From: Jonathan Best <Jonathan.Best@arun.gov.uk>
Sent: 05 January 2026 14:56
To: Planning.Responses <Planning.Responses@arun.gov.uk>
Cc: Simon Davis <Simon.Davis@arun.gov.uk>
Subject: BE/143/25/OUT

Land East of Heath Place Bersted PO22 9SL.

I have reviewed this application with regards to ecology and Biodiversity Net Gain.

Drawing Title
Biodiversity Habitats Plan
Drawing Number
852 - 2
Date
15.12.2025
Scale
1:150 @ A1

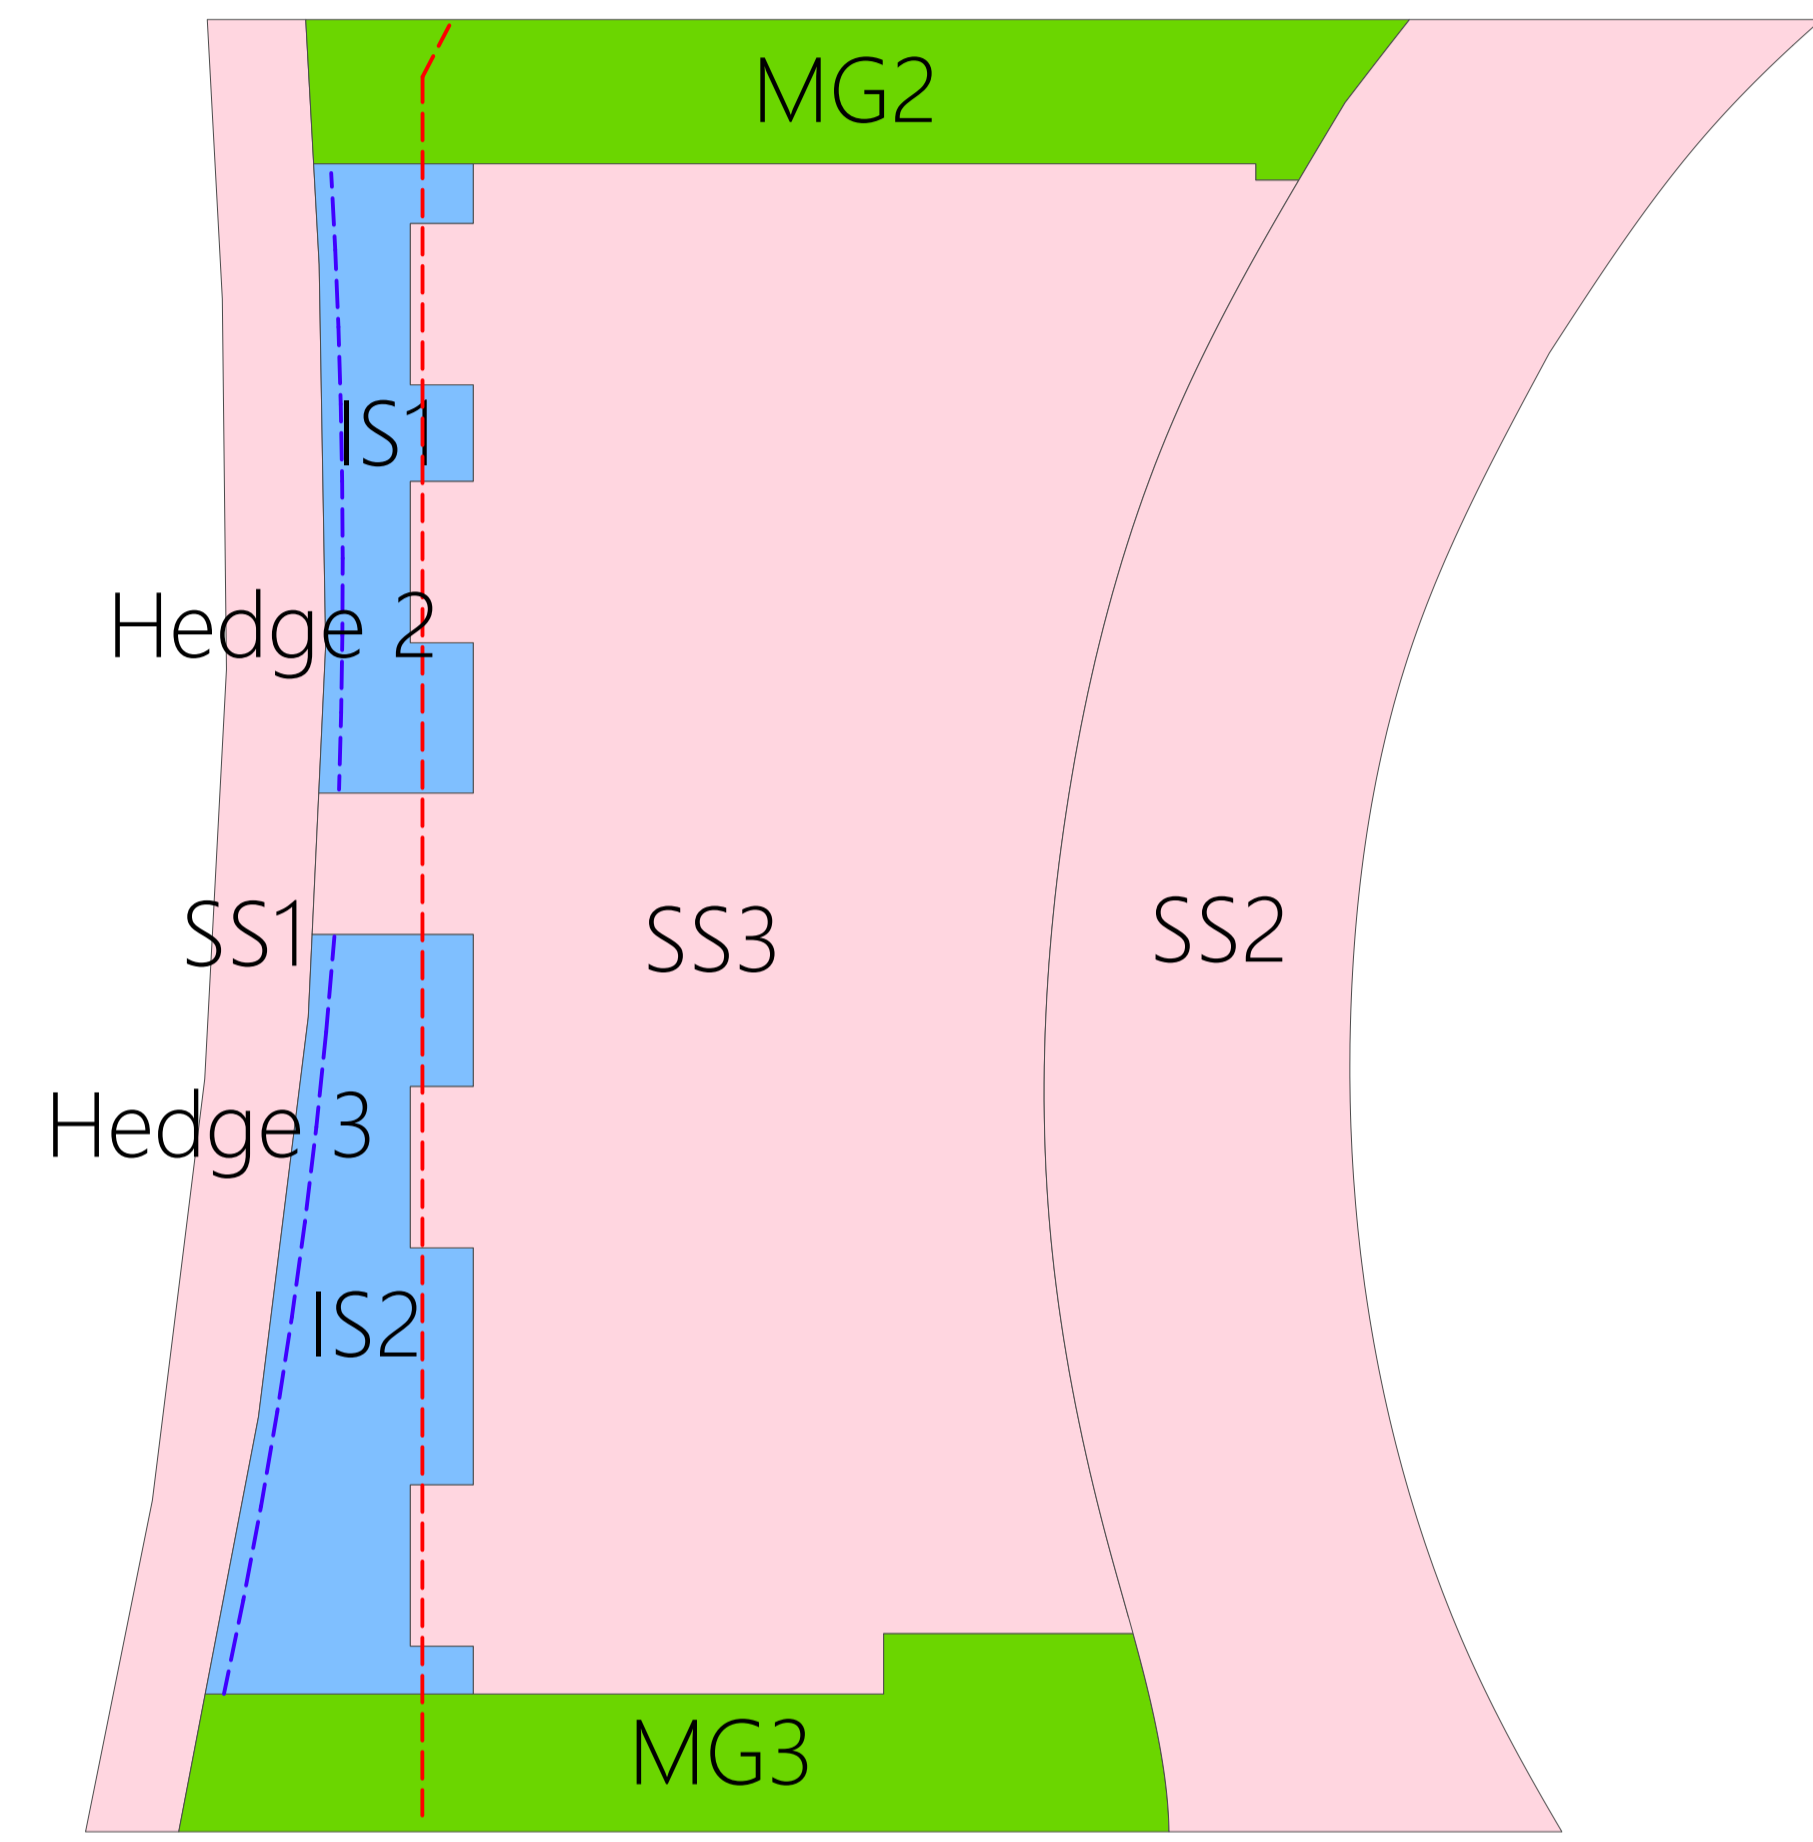
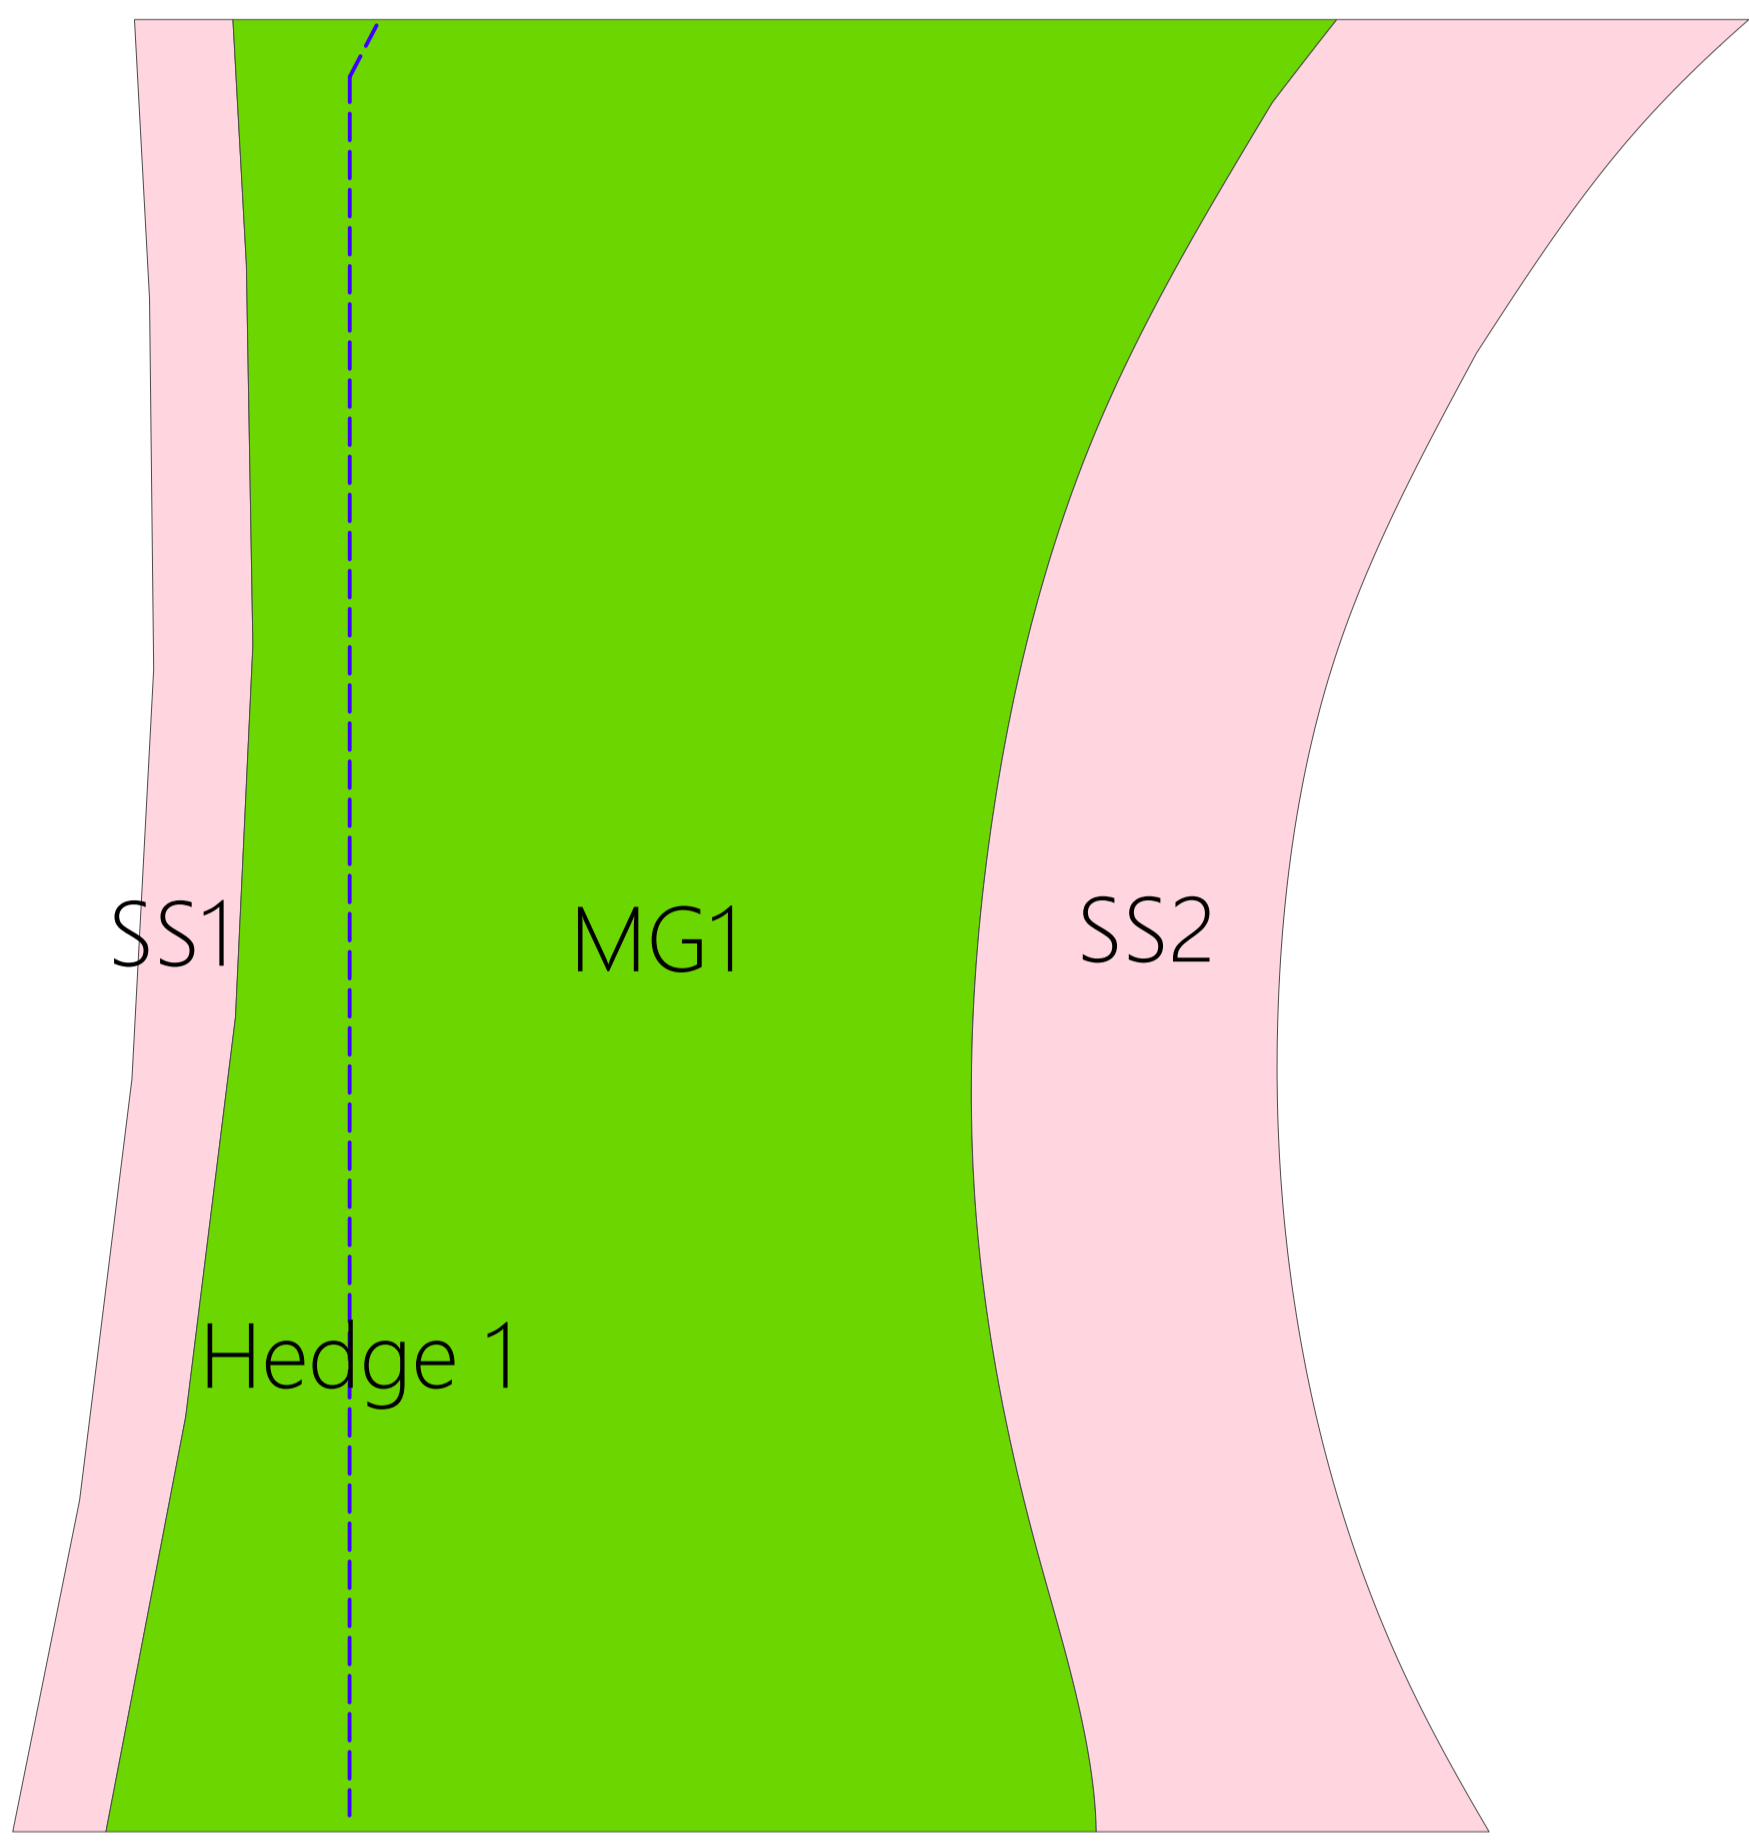
The BNG metric and assessment shows a loss 67.83% of habitat units. Offsite BNG units will be required.

The landscaping layout provides limited ecological value. The introduced shrubs are non-native and the hedge is Privet.

Inclusion of a mixed native hedge should be considered as well as native shrub planting and inclusion of ecological features such as swift bricks and bat boxes.

This would help increase the ecological value of the site and meet Policy ENVDM5.
